Jade3 Architecture Ltd

Job reference: 2023 enquiry 76

Address: **Stancliffe House Farm site**
Woodhead Road
Wortley
Sheffield, S35 7DA

Extra notes: Additional information for the demolition of existing rainbow hill boarding kennel block and construction of new C3 one off dwelling at Stancliffe House Farm site, at Woodhead Road, Wortley, Sheffield S35 7DA

Project Title
cross section analysis

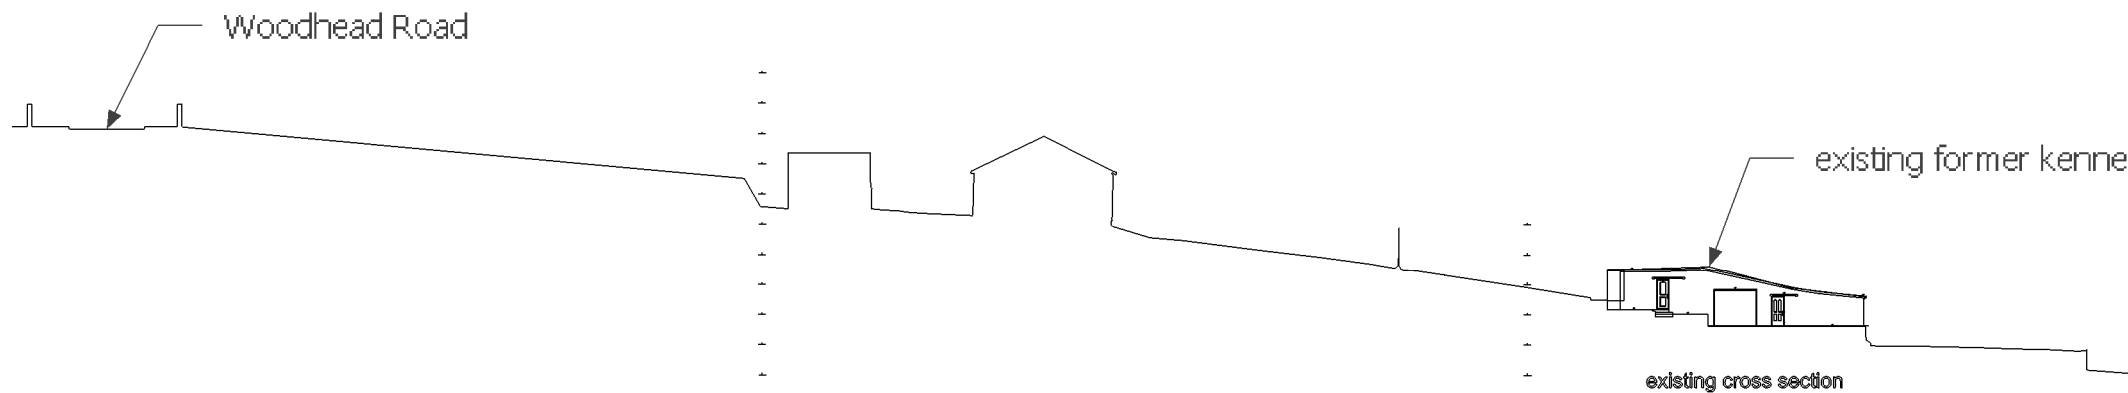
Greenbelt- you were unable to support the application based on the lack of sufficient Green Belt justification and incorrect policy assessment.

Additional drawings study showing the proposals superimposed onto the former kennel and also a cross section is provided that included Woodhead Road so that you can appreciate how much the site slopes down.
